General	
GEN2.7	At D2 the Applicant submitted an update to the Rights of Way and Access Plan [REP2- 003]. This was updated to address comments made by NCC at D1. What are NCC's comments on the updated plan?	The Council supports the updated Rights of Way and Access Plan and has no further comments to make at the present time.
	Air Quality	
AQ2.2	Is NCC content that the Proposed Development will not significantly increase the levels of air pollution within the wider area by increasing the number of vehicles?	<p>Baseline levels from DEFRA background maps for thirty-five of the nearest receptors (ten in Part A and twenty-five in Part B) shows the existing background levels of the following atmospheric pollutants;</p> <p>Nitrogen Dioxide (NO₂) – 6 to 33 µg/m³, and; Particulates 10 and 2.5 micron (PM₁₀ / PM_{2.5}) – 8 to 24 µg/m³.</p> <p>The modelling of nitrogen dioxide (NO₂) impacts for thirty-five human receptors has shown that the difference between Do-Minimum (without dualling) and Do-Something (dualling of the two sections as proposed) results in an increase of 1.0 microgramme per cubic metre (µg/m³) or less for the opening year (2023) for the majority of receptors. Only one recept

© WSP UK Ltd

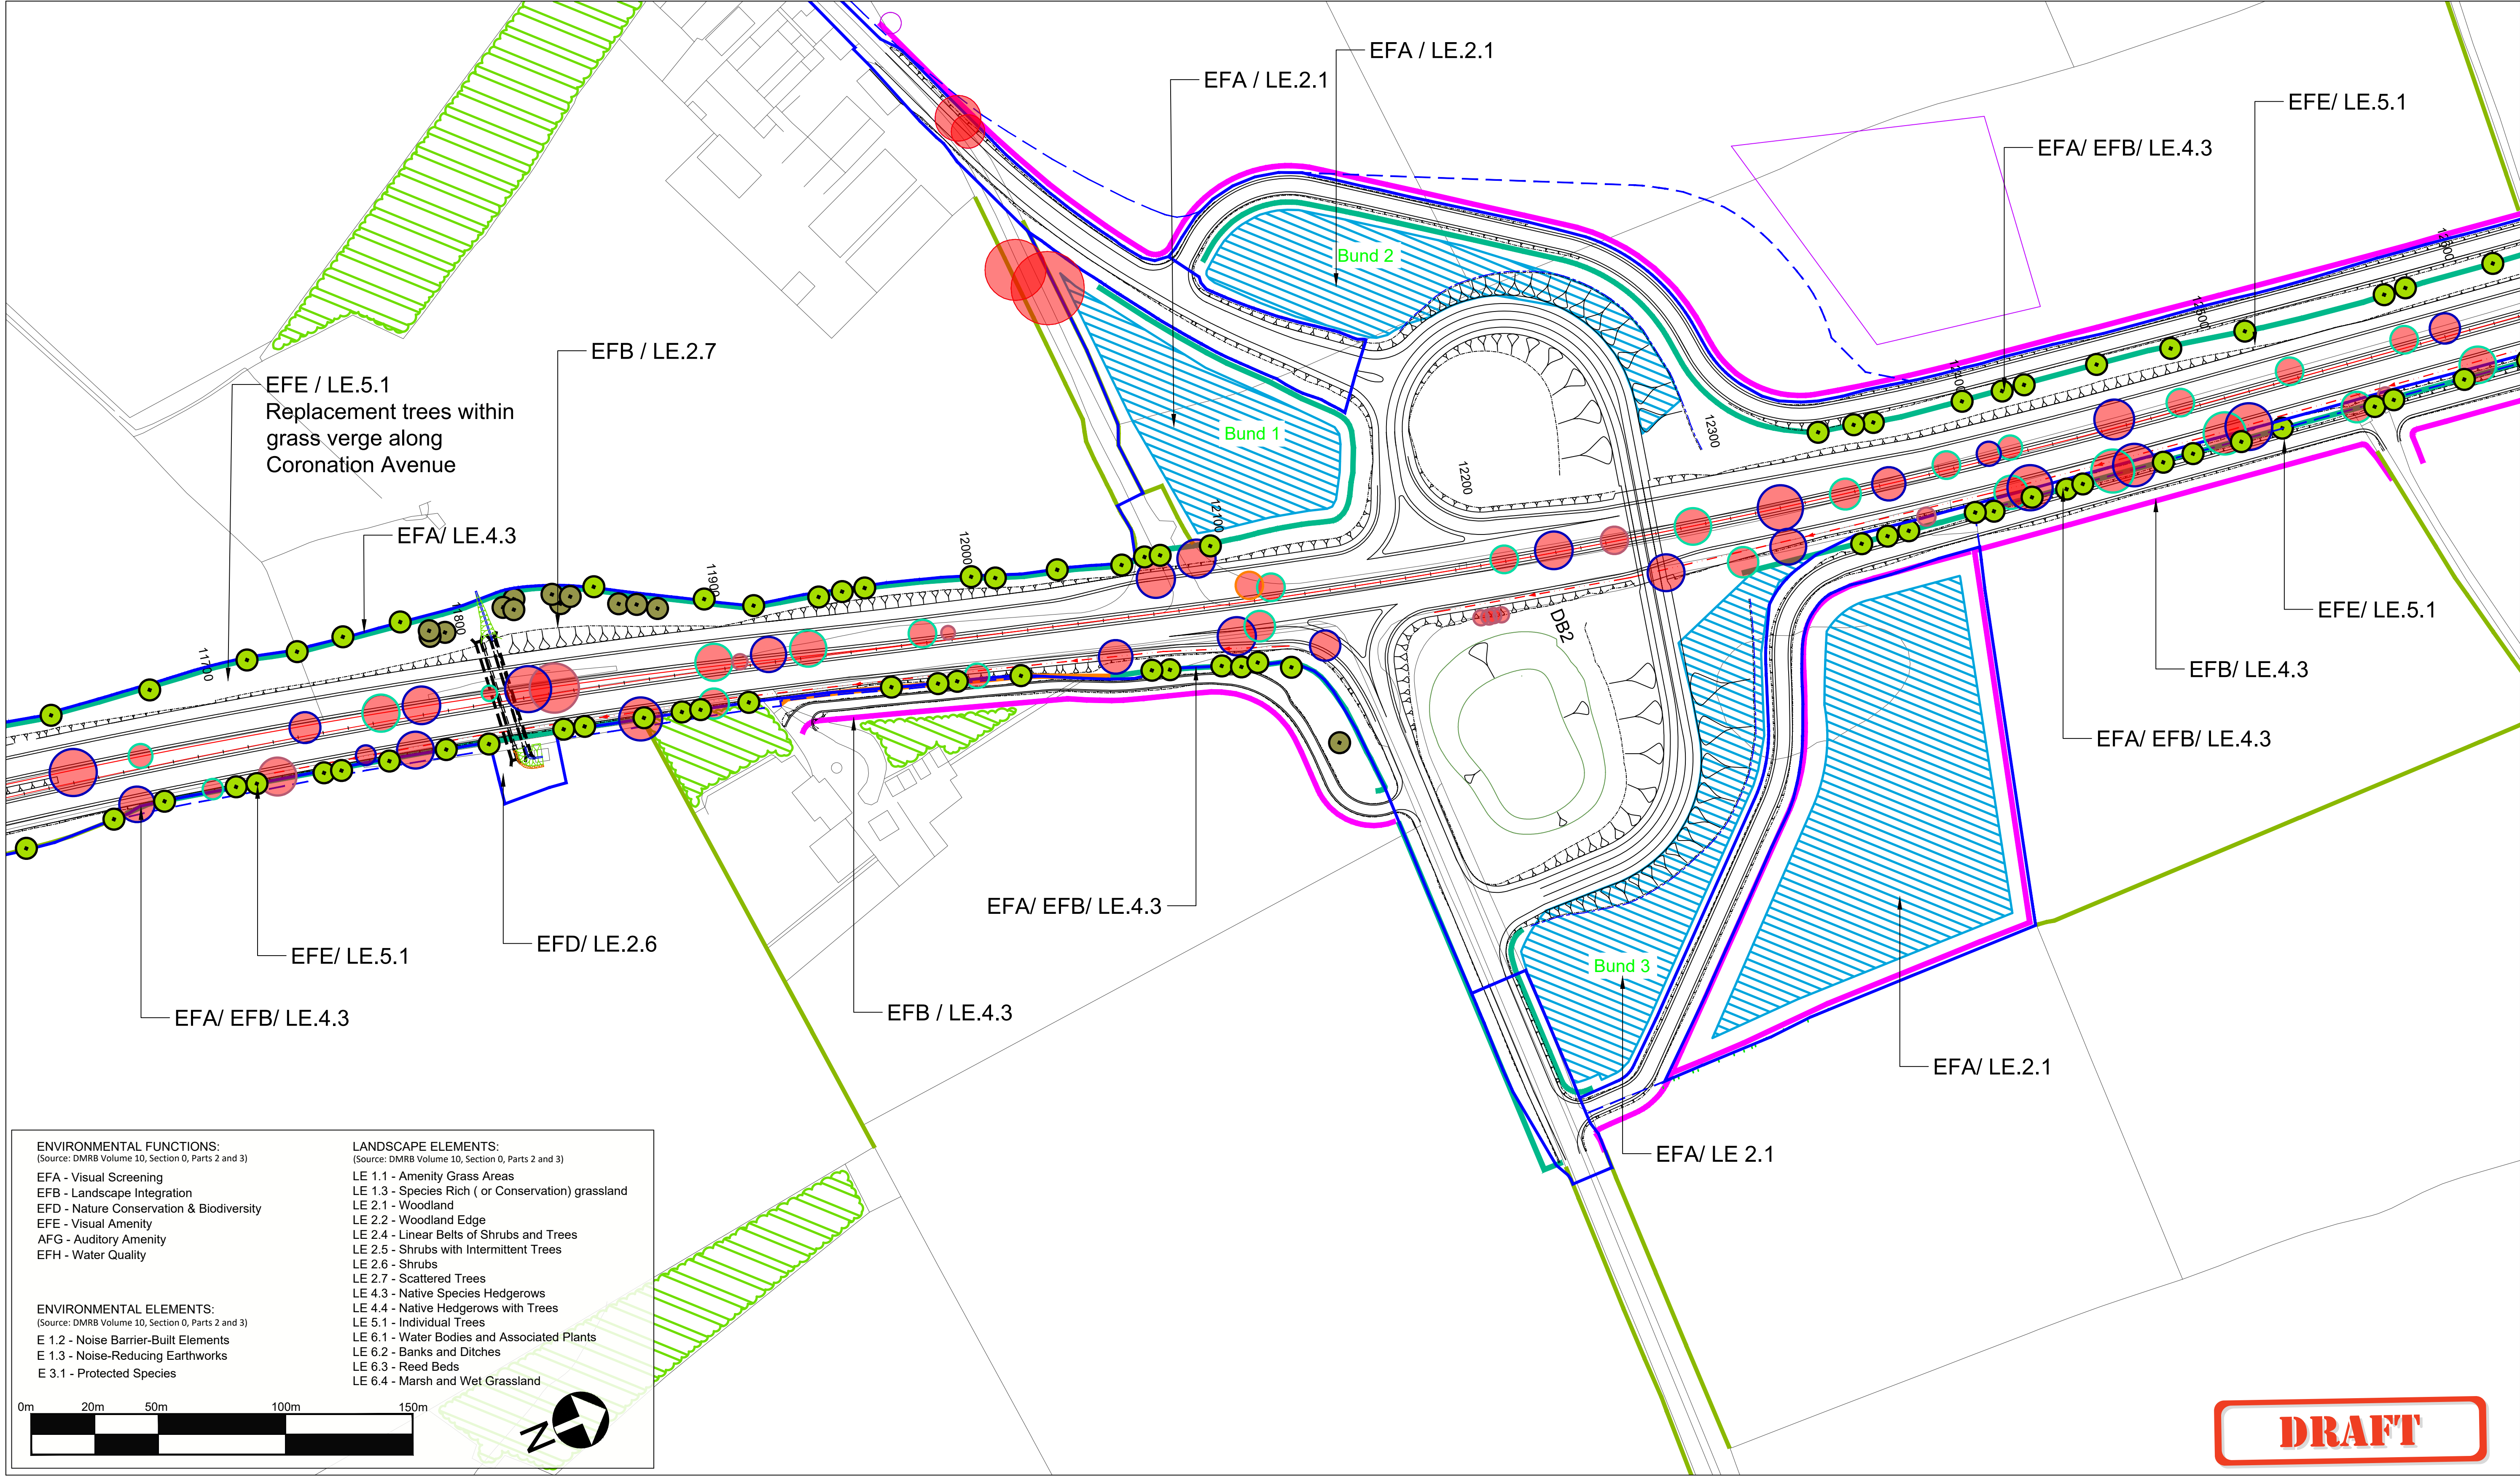
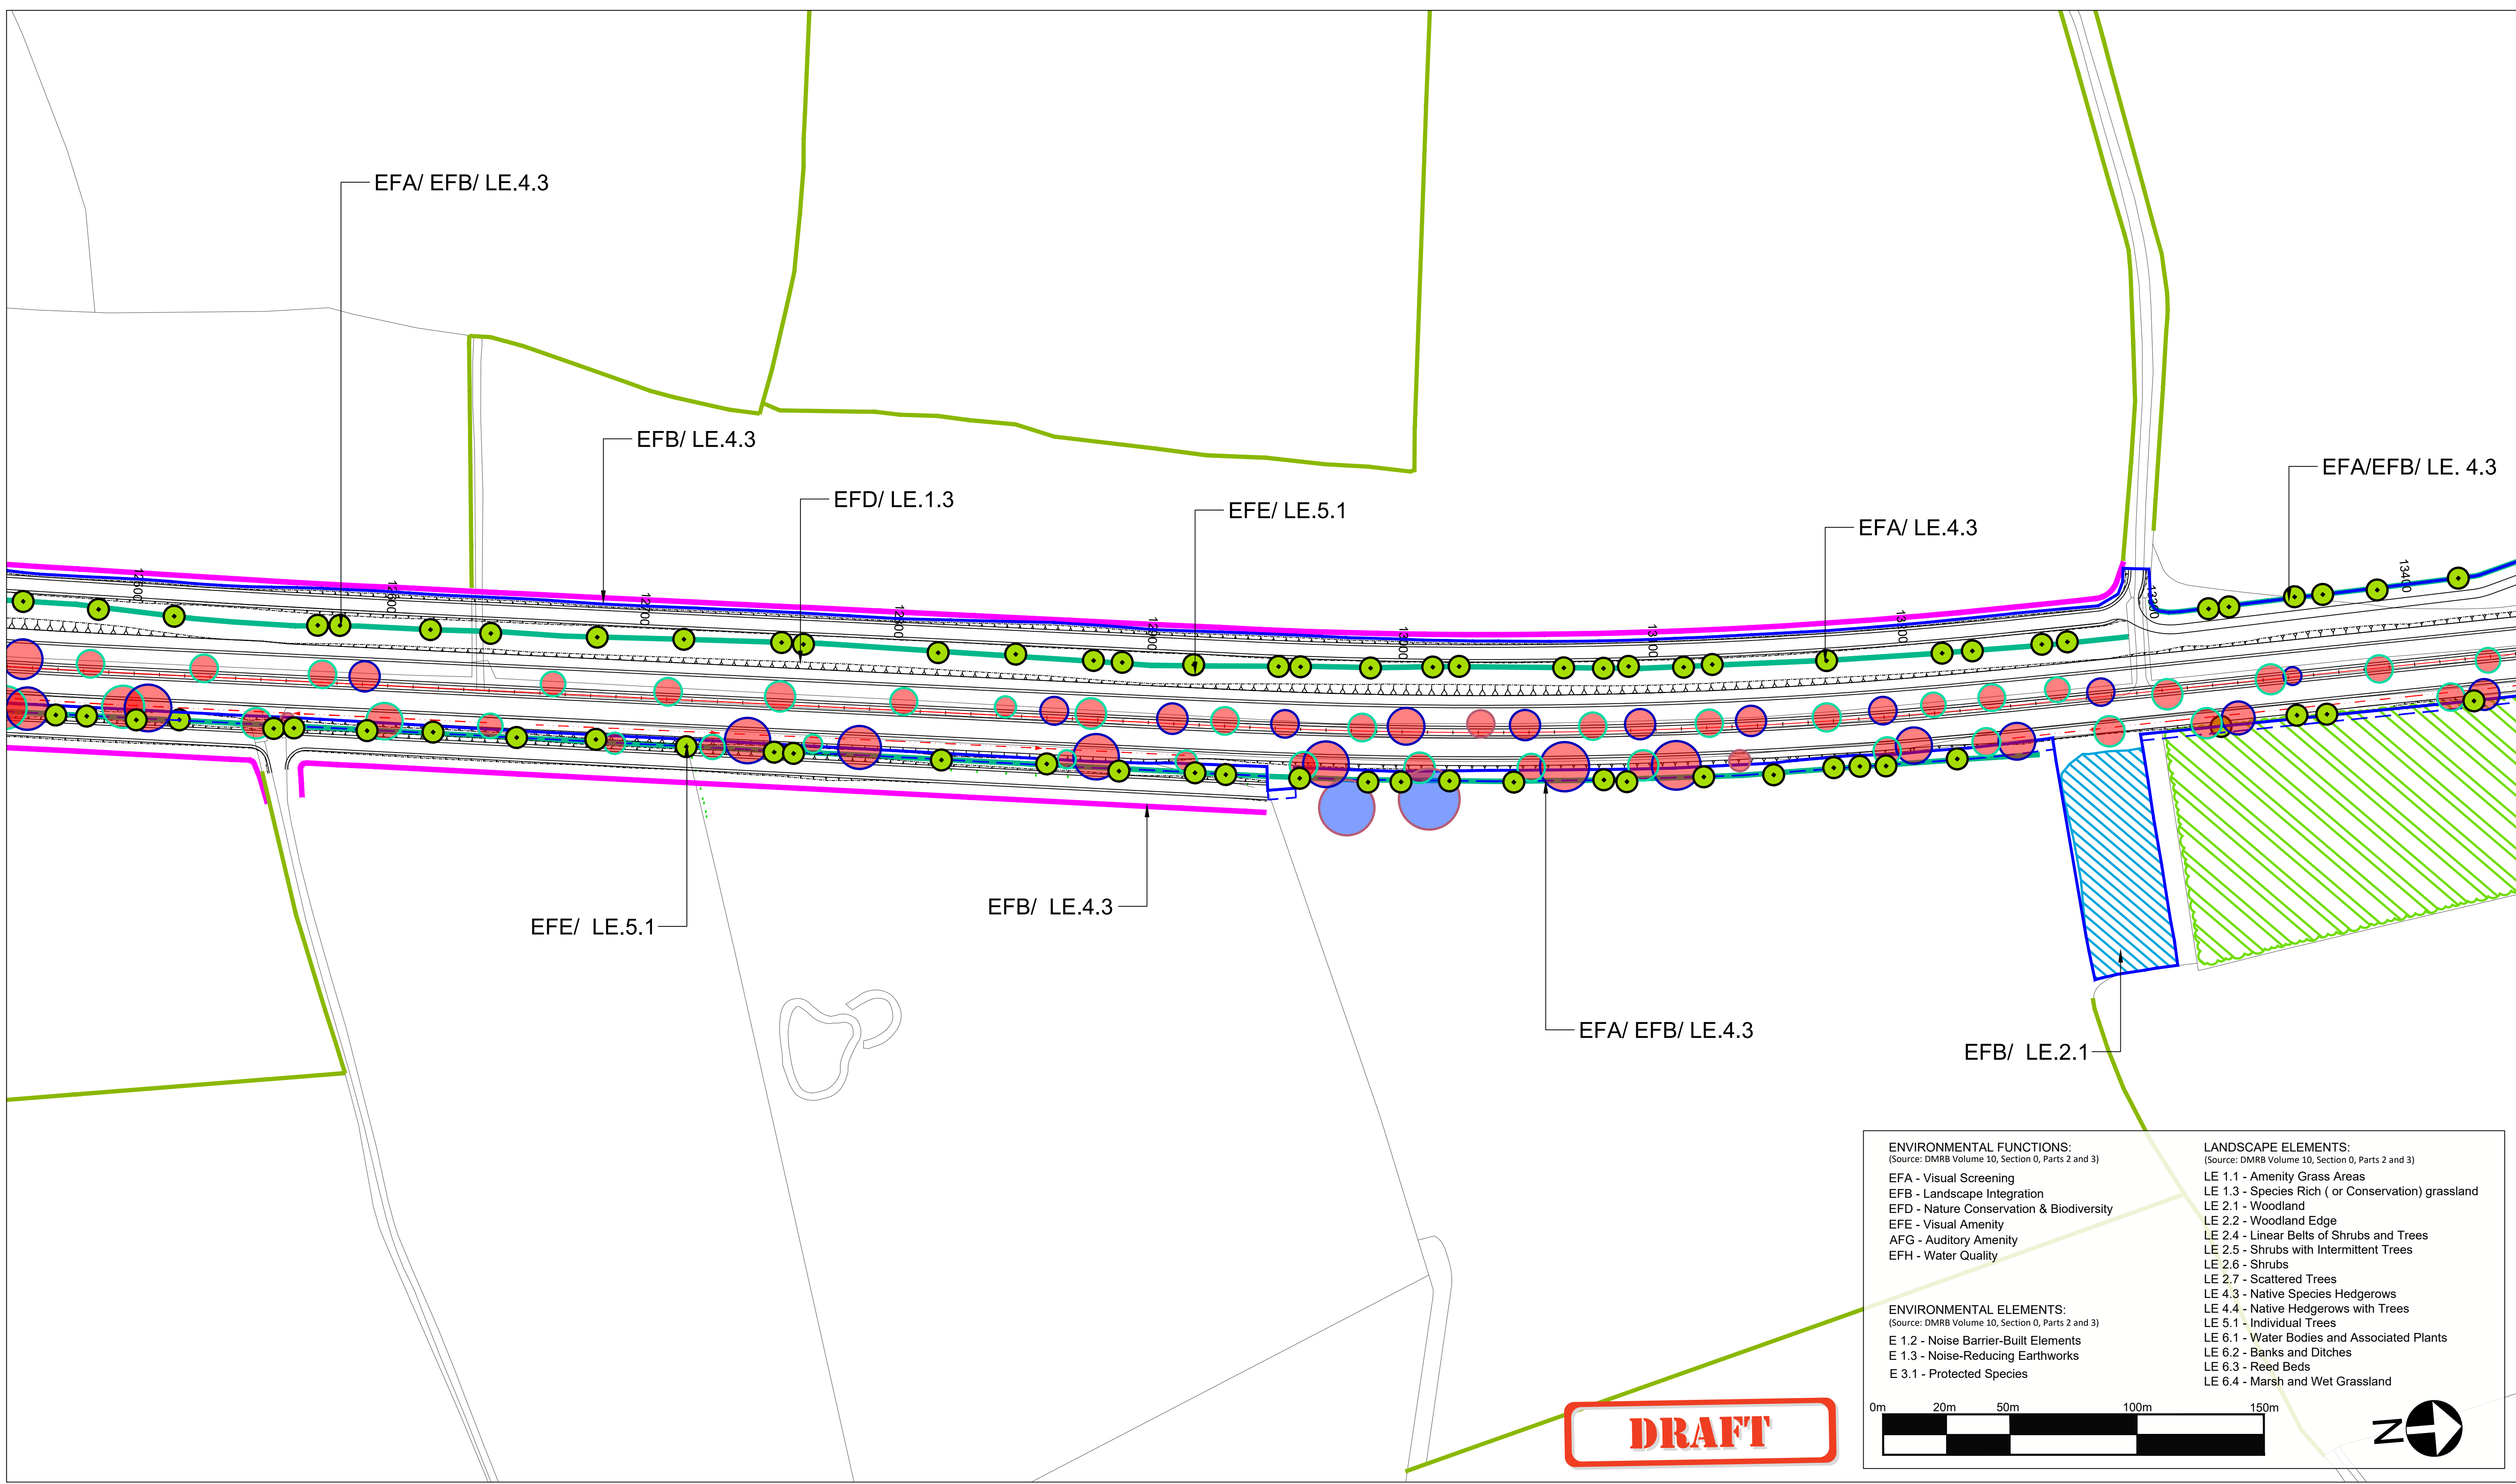
PART 2: no comments to make. The Council has reviewed the changes to Schedule 4 contained in the draft DCO – Revision 4 with respect to public rights of way and supports all of the changes.
	Landscape and Visual	
LV2.2	The plans which form Appendix LV.2 Trees to be Removed and Replaced at Coronation Avenue WQ LV.1.8 [REP1-044] are annotated 'Draft'. The Applicant is asked to explain how this relates to the requirement in R5(3) of the dDCO for the landscaping scheme to include a strategy for the replacement of trees which are to be removed at Coronation Avenue? IPs are asked to comment on the proposals for Coronation Avenue.	The number and location of replacement trees for Coronation Avenue as illustrated on the draft plans are appropriate. These proposals are now also reflected on 6.31 Landscape Mitigation Masterplan – Part A – Rev 2 submitted at Deadline 4.
LV2.6	Appendix LV3 Response to LV.1.13 [REP1-051] considers potential additional mitigation measures, their suitability and the prospect of potentially reducing significant effects to non-significant. What are the views of IPs in respect of these further potential mitigation measures?	Additional mitigation has been discussed and agreed with the Applicant at West Moor and Fenrother junctions and to the west of Causey Park Bridge. This is reflected on 6.31 Landscape Mitigation Masterplan – Part A – Rev 2 submitted at Deadline 4. This represents a welcome improvement in the landscape mitigation proposals although NCC agree with the assessment provided by the Applicant that the previously identified significant effects would remain.
